Application No: FG/46/20/PL
Site Address: The Tudor Close Public House Ferringham Lane Ferring BN12 5NQ
Description of works: Conversion of the existing Public House (Class A4) to create 7 No residential units comprising 5 No 1-bedroom units & 2 No 2-bedroom units & the erection of 2 No 2-bedroom semi-detached chalet bungalows with associated car parking & landscaping. This application may affect a Public Right of Way.

Thank you for your internet representation made on 14th May 2020 which has been recorded as an objection with the comments as follows:

Drawing Title:
Landscape Plan
Block Plan
As Proposed

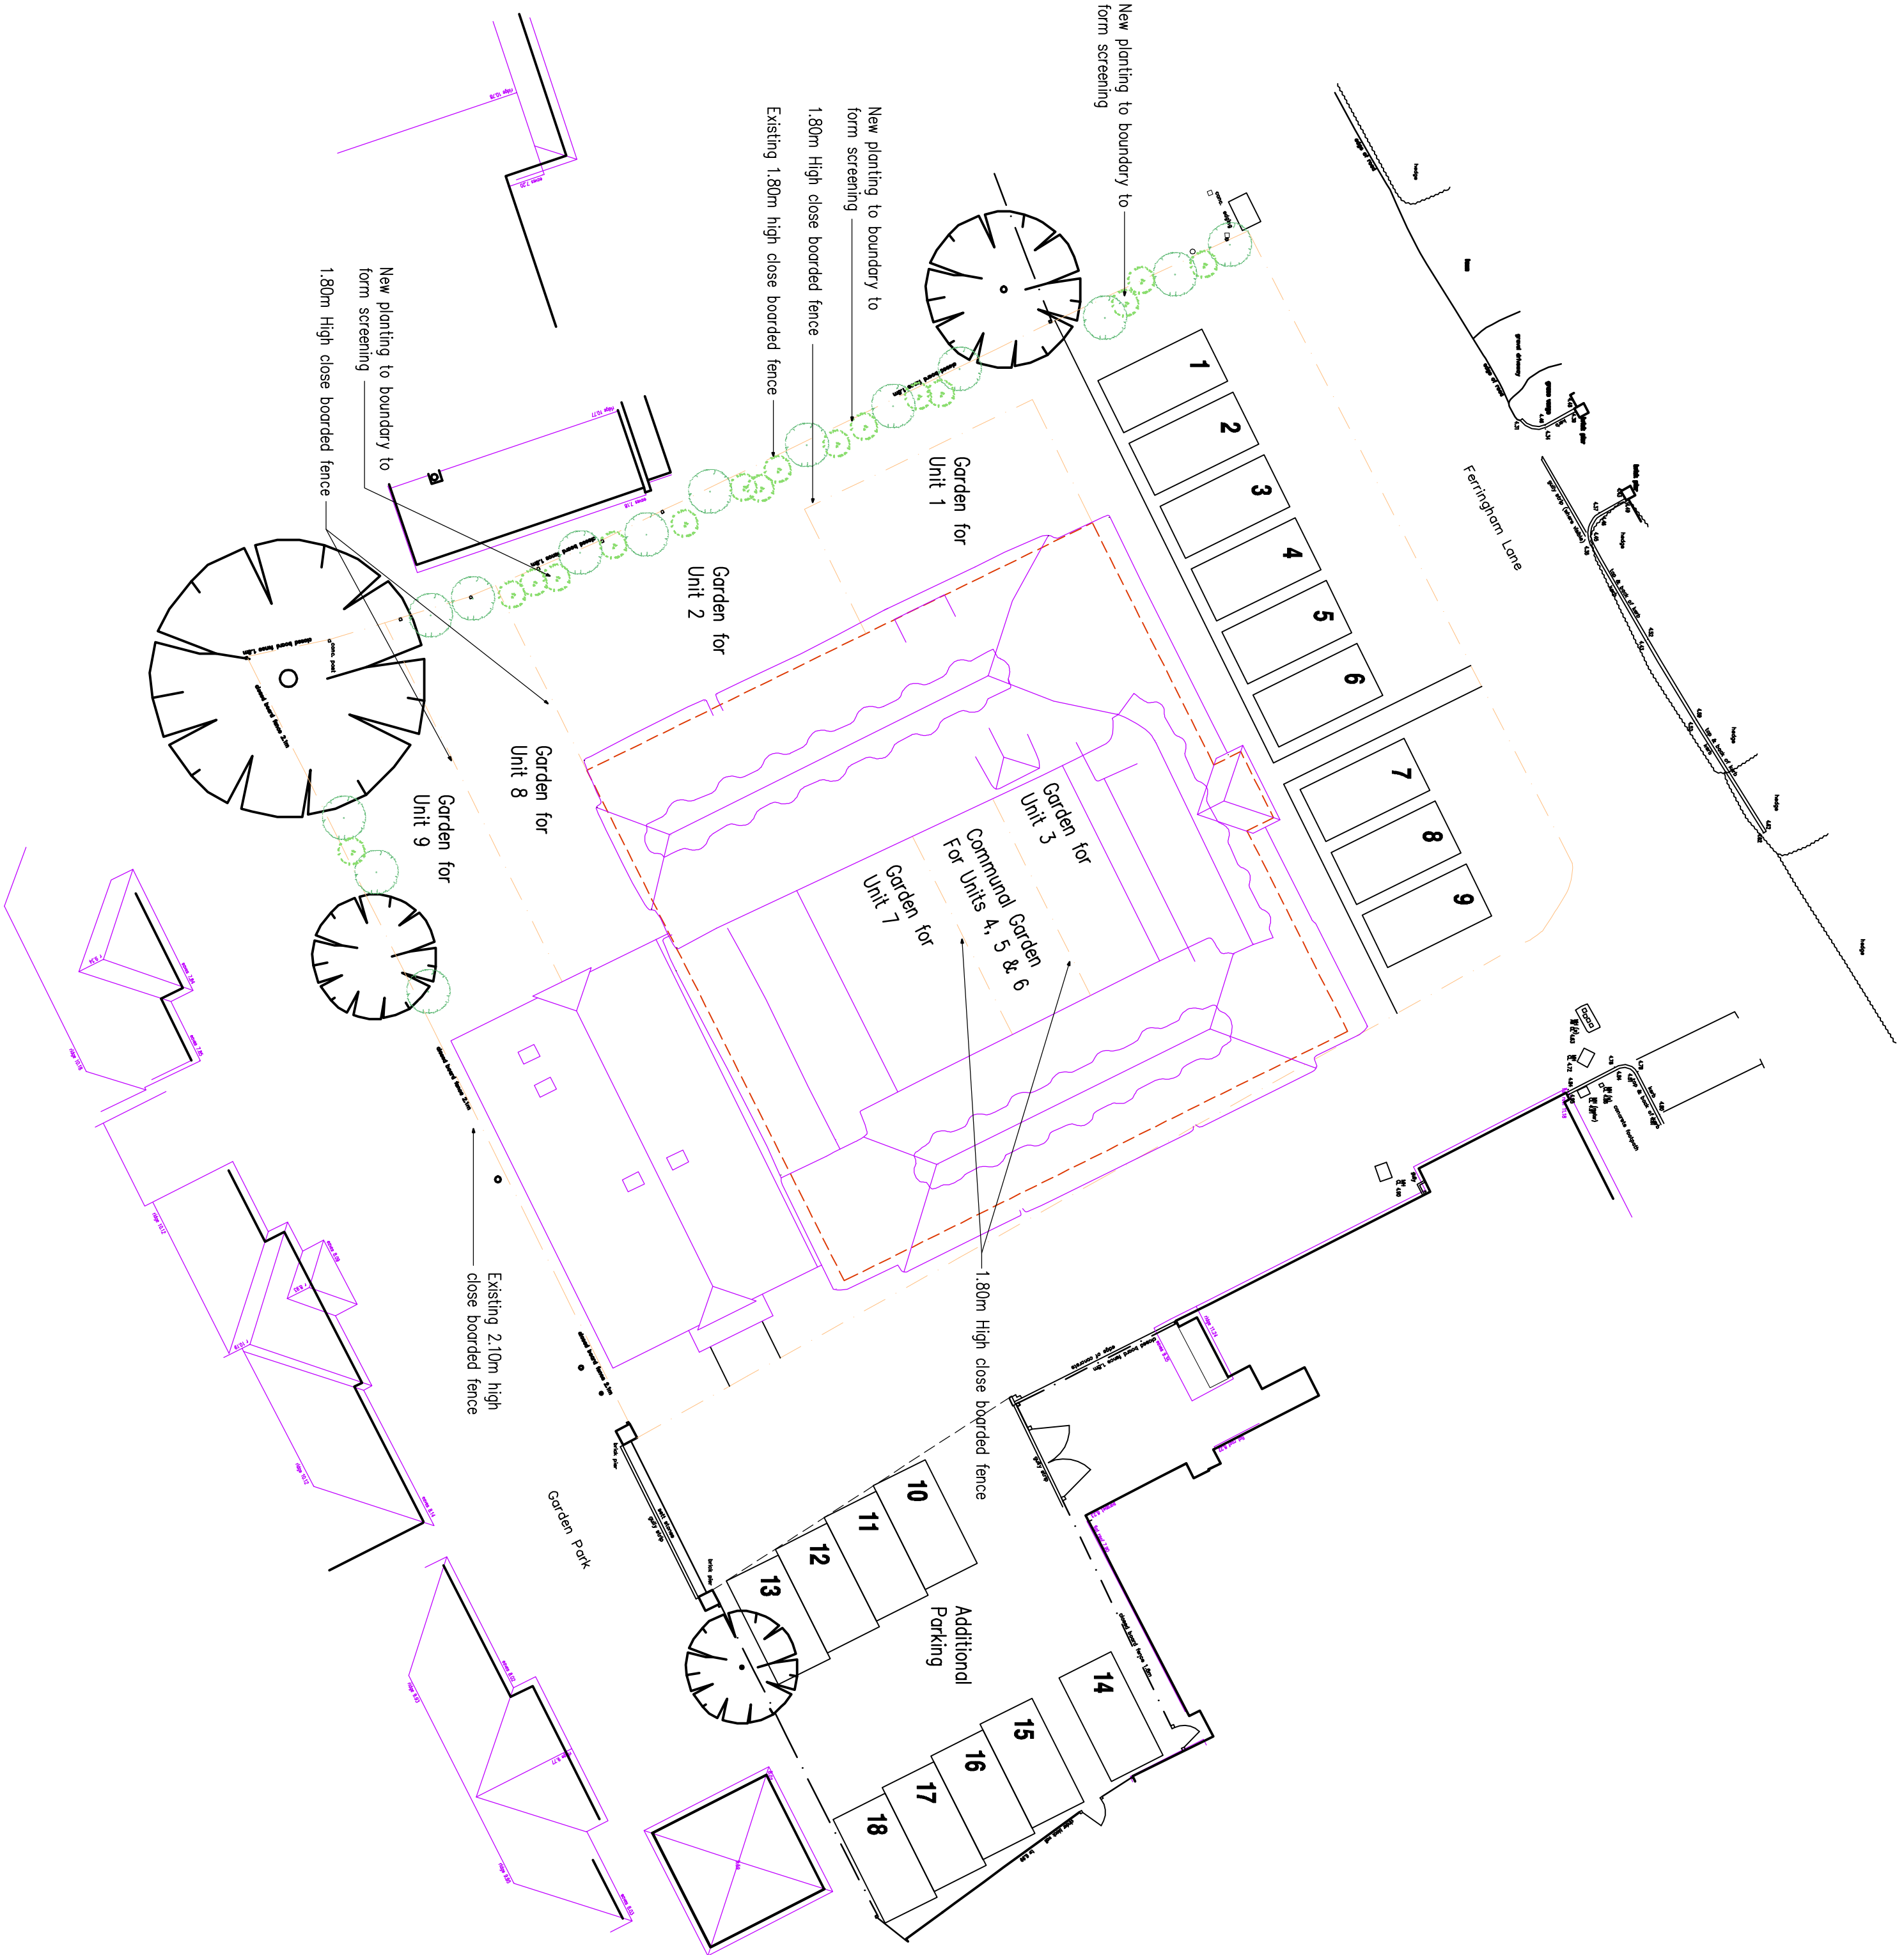
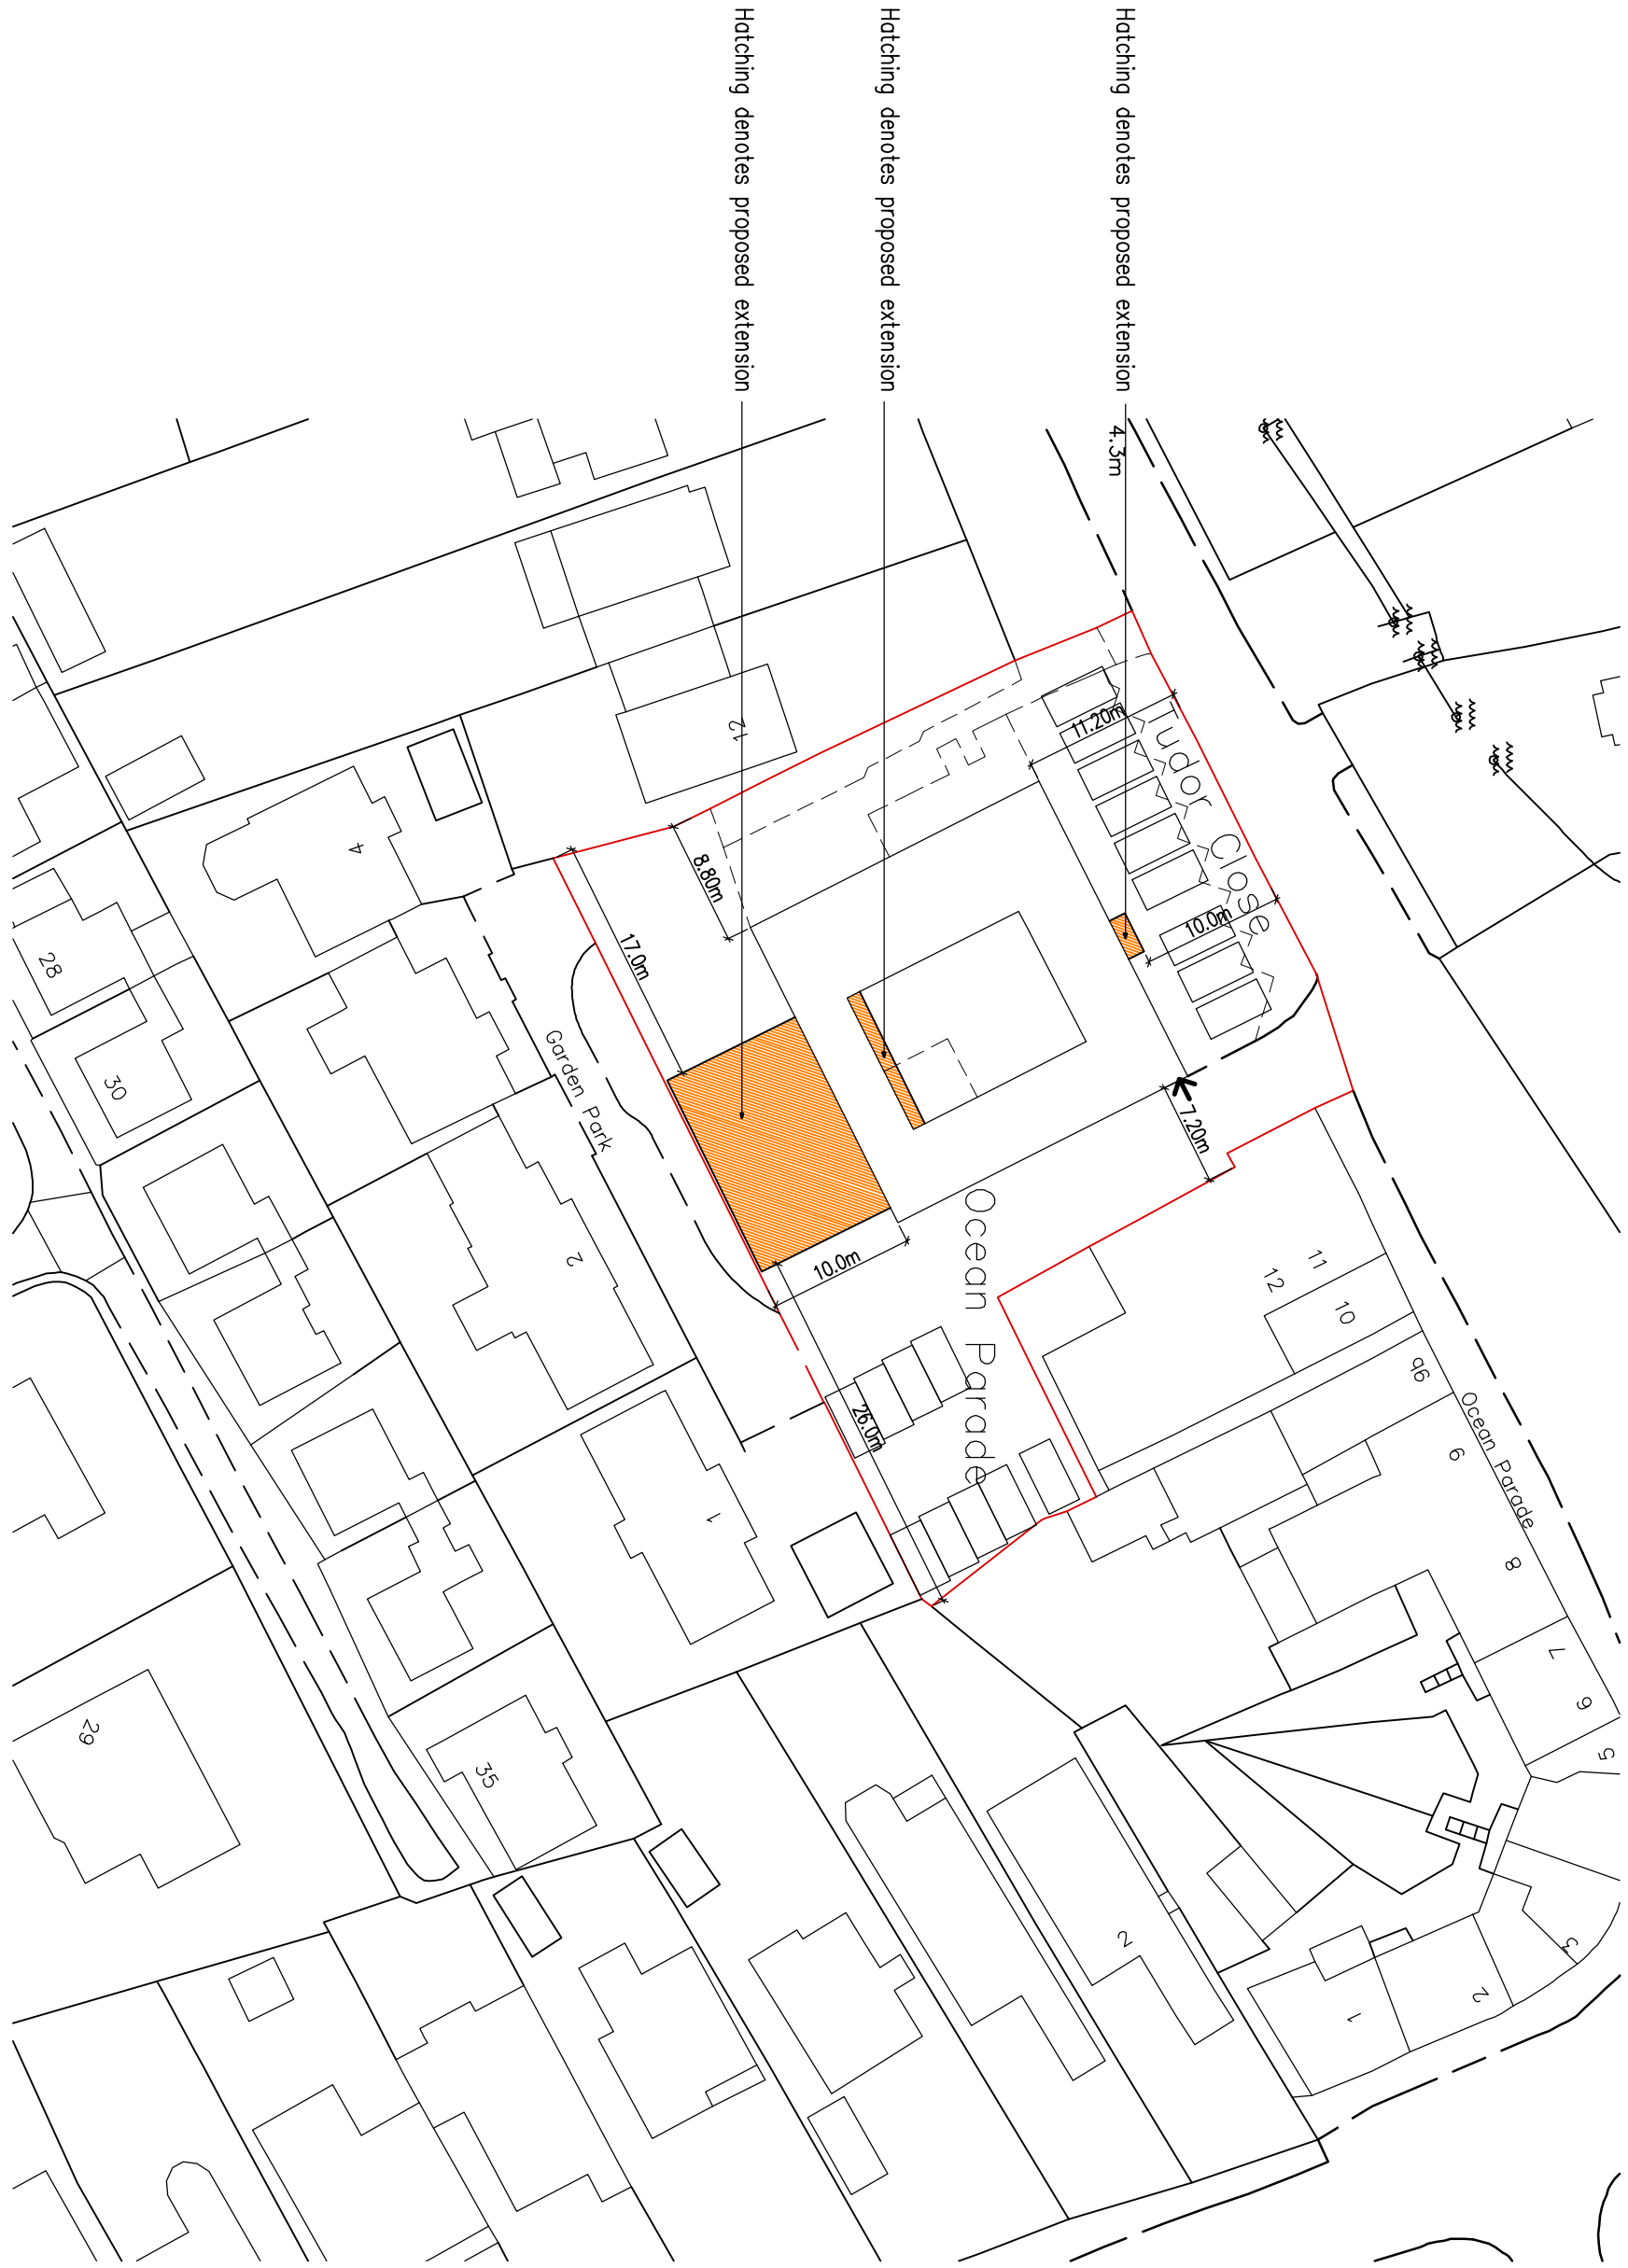
Firstly, I have 5 beautiful large trees growing right next to my boundary fence.

A Catalpa (Indian Bean Tree), a Copper Leaf Malus, a Laburnum and two Silver Birches. I have been informed that digging the foundations of the bungalows will cause extensive damage to their roots. They will become unstable and probably die. This is a situation that cannot be contemplated or envisaged. I do not want to lose my trees under any circumstances, but if this happened, I would want them to be replaced with the same trees of similar size.

The tree roots would always be a problem for any building in such close proximity.

- I understand that to build a house of that height, the space between my fence and the house wall should legally be at least 2 metres.
- The line of sight turning right from the access road on to Ferringham Lane is often totally obscured by vans and cars parked directly outside Kendrick's coffee shop. This necessitates creeping forward half way across Ferringham lane right in line of oncoming traffic. This dangerous situation would need to be addressed as there will possibly be 9 more vehicles plus delivery vans and visitors entering and leaving. The access road, that our bungalows have right of way over, should become a no parking area to allow for the free flow of all vehicles including the emergency services.
